Subject: Sears Plat SUB23-001; Mercer Island, WA
Comment Response Letter #3

Thank you for your review of the Preliminary Short Subdivision and SEPA Review applications permit documents and your comments letter dated November 27, 2023. We at Navix Engineering have prepared comment responses below and hope you find the resolution of the review comments acceptable. Please feel free to contact me with any questions or coordination items you have.

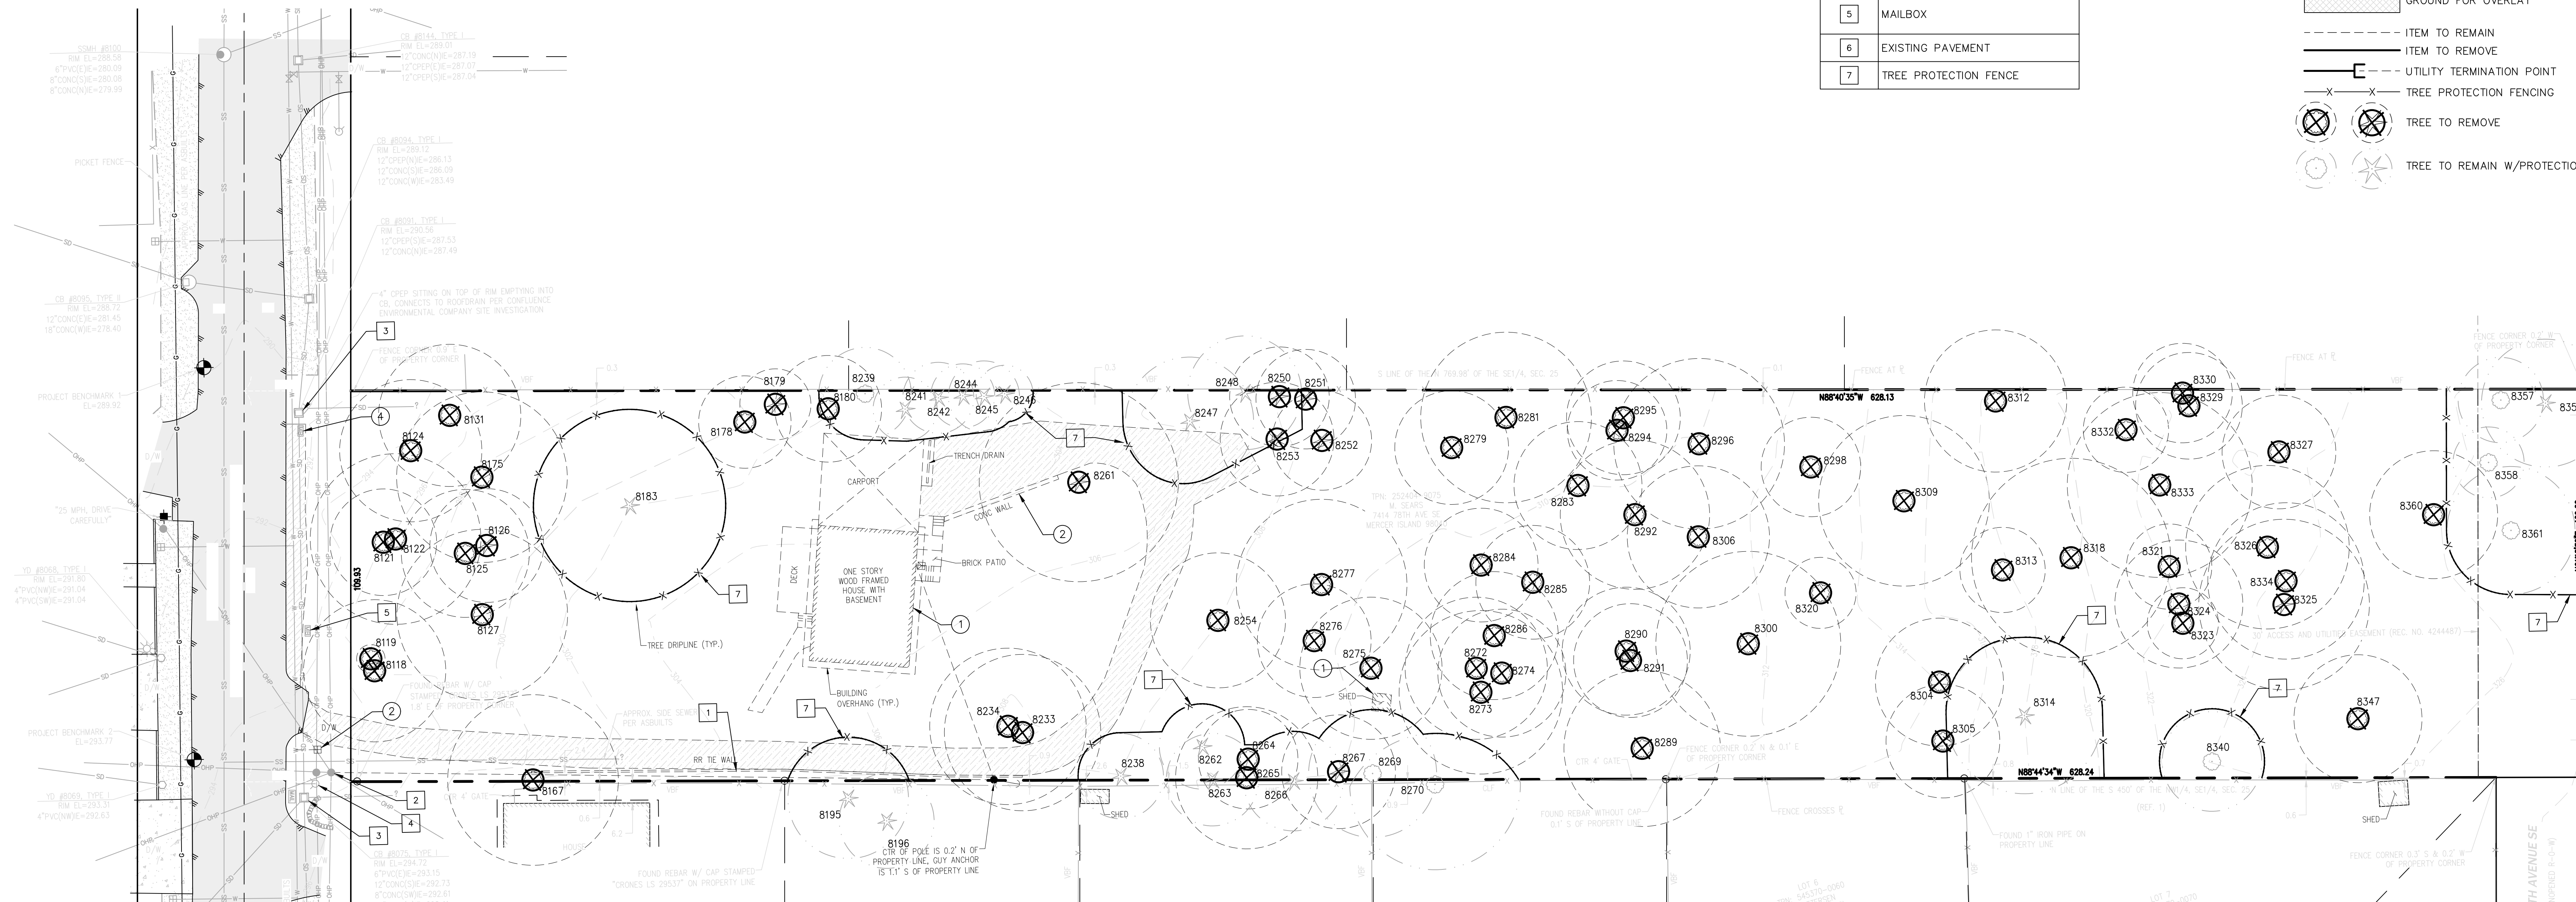
3. The provided tree inventory worksheet and the table in the arborist report and site plan do not match. Some trees are listed as exceptional in one document, but not the other. The arborist report lists tree 8118 as exceptional, but the tree inventory worksheet does not. The tree inventory worksheet lists tree 8234 as exceptional, but the arborist report does not. Based on the arborist report, tree 8325 should be included in the list of trees over 24 inches on the tree inventory worksheet as well. Please revisit the arborist report, site plan, and tree inventory worksheet to ensure that they are consistent with each other.

Response: All documentation about the trees has been updated to be consistent.

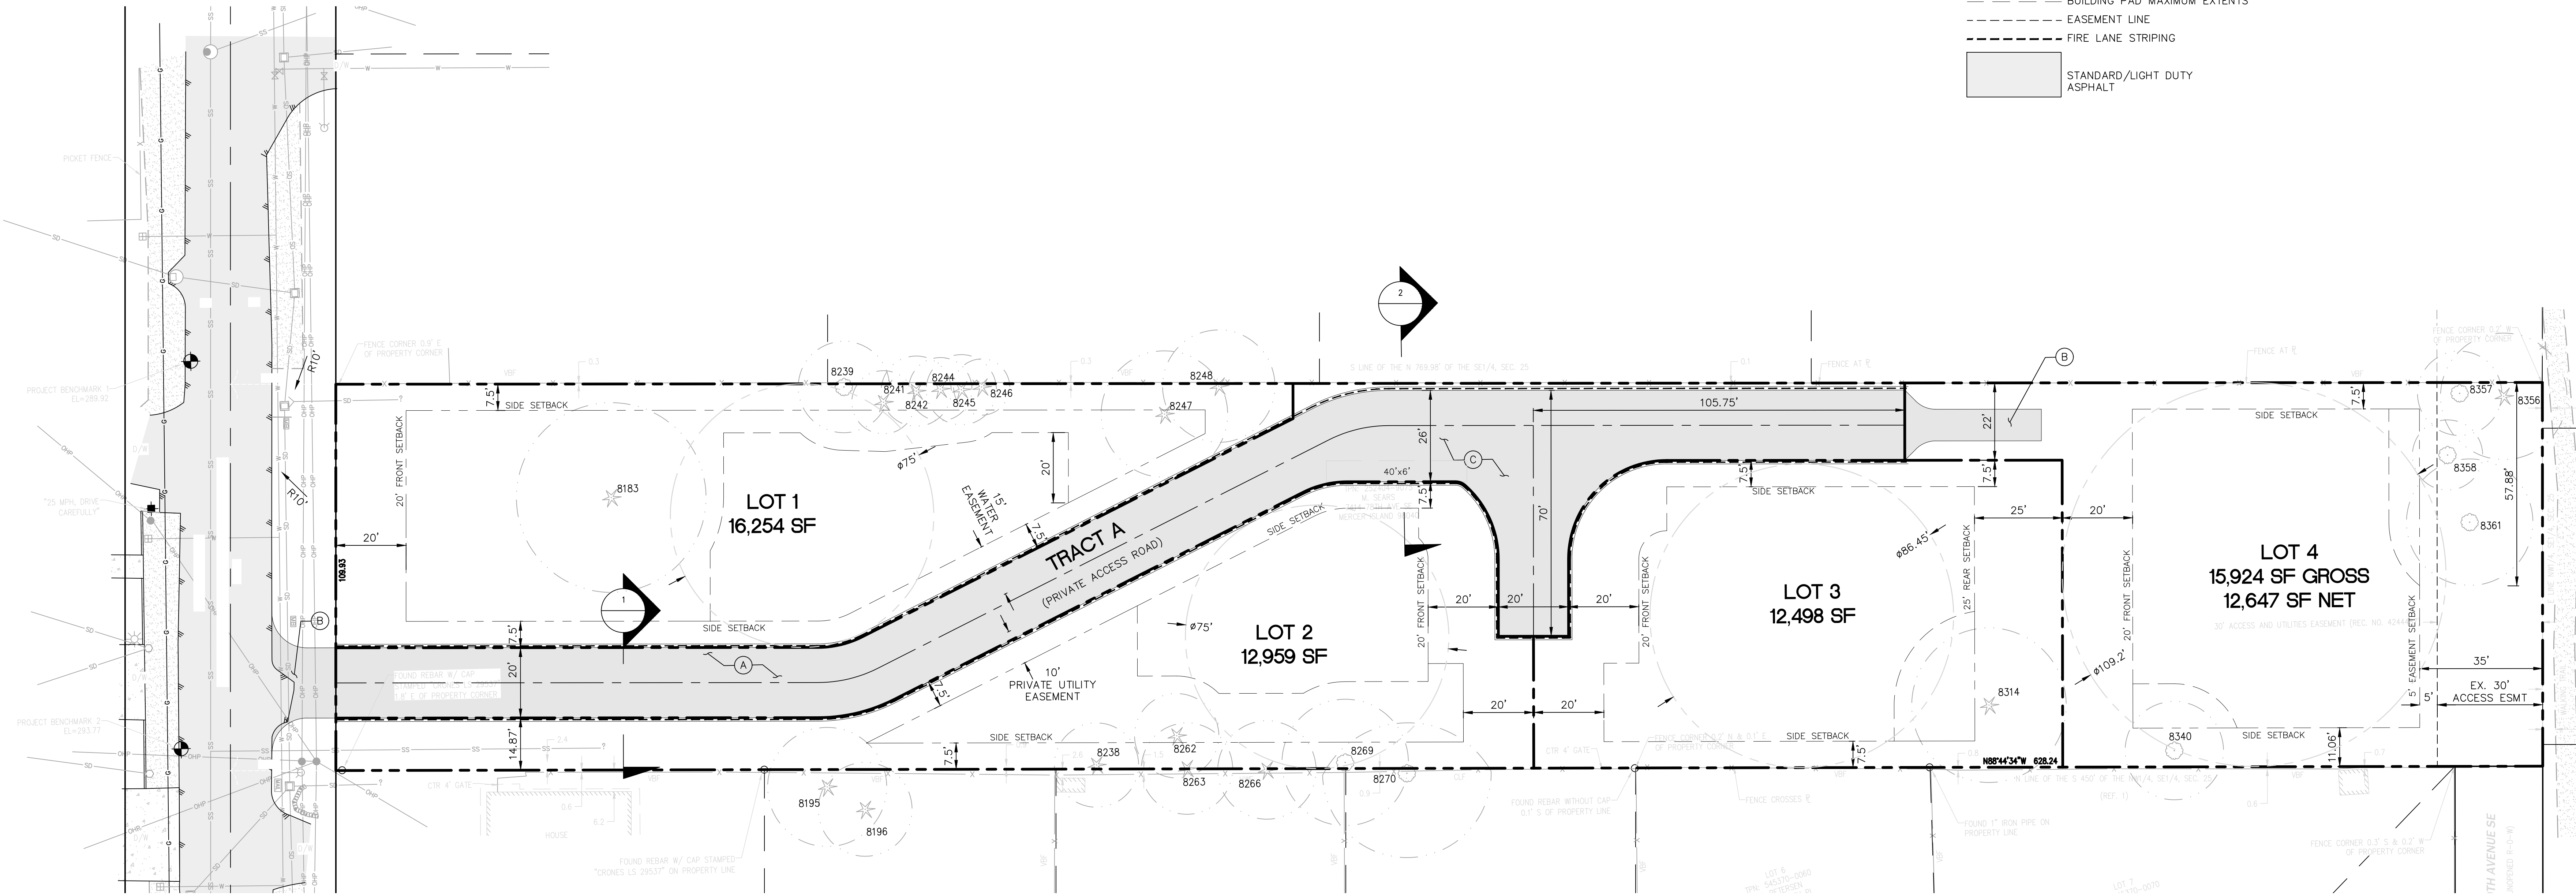
2. MICC 19.02.020(C)(1)(c)(i)(b) requires that for a lot with a lot width of more than 90 feet, the sum of the side yards' width shall be a width that is equal to at least 17% of the lot width. The site plan shows that the lot width of Lot 4 is 106.7 feet, which would require the sum of the side yard setbacks to be at least 18.14 feet, with a minimum side yard depth of 5.99 feet. Please revise the building pad of Lot 4 to meet the setback requirements listed in MICC 19.02.020(C)(1)(c)(i)(b).

3. MICC 19.09.090(A)(1)(a) requires that building pads shall be located to minimize the removal of trees and impacts to trees and vegetation required for retention. Please revise the building pads to account for impacts to trees and vegetation as per arborist comments below.

1. The tree protection shown on the site plan is right on the building pad, which would be unrealistic in the field. The building pads will need at least five feet of clearance for walking and machine access. The tree protection and limits of allowable disturbance will need to be adjusted to account for the five-foot clearance.

Response: Lot width is 109.20 feet. A total setback width of 18.56 feet is provided. 7.5 feet on the north side of the lot and 11.06 feet on the south side.

Response: The building pads have been updated to provide a minimum of 5 feet from the drip lines.

Response: The building pads have been updated to provide a minimum of 5 feet from the drip lines.
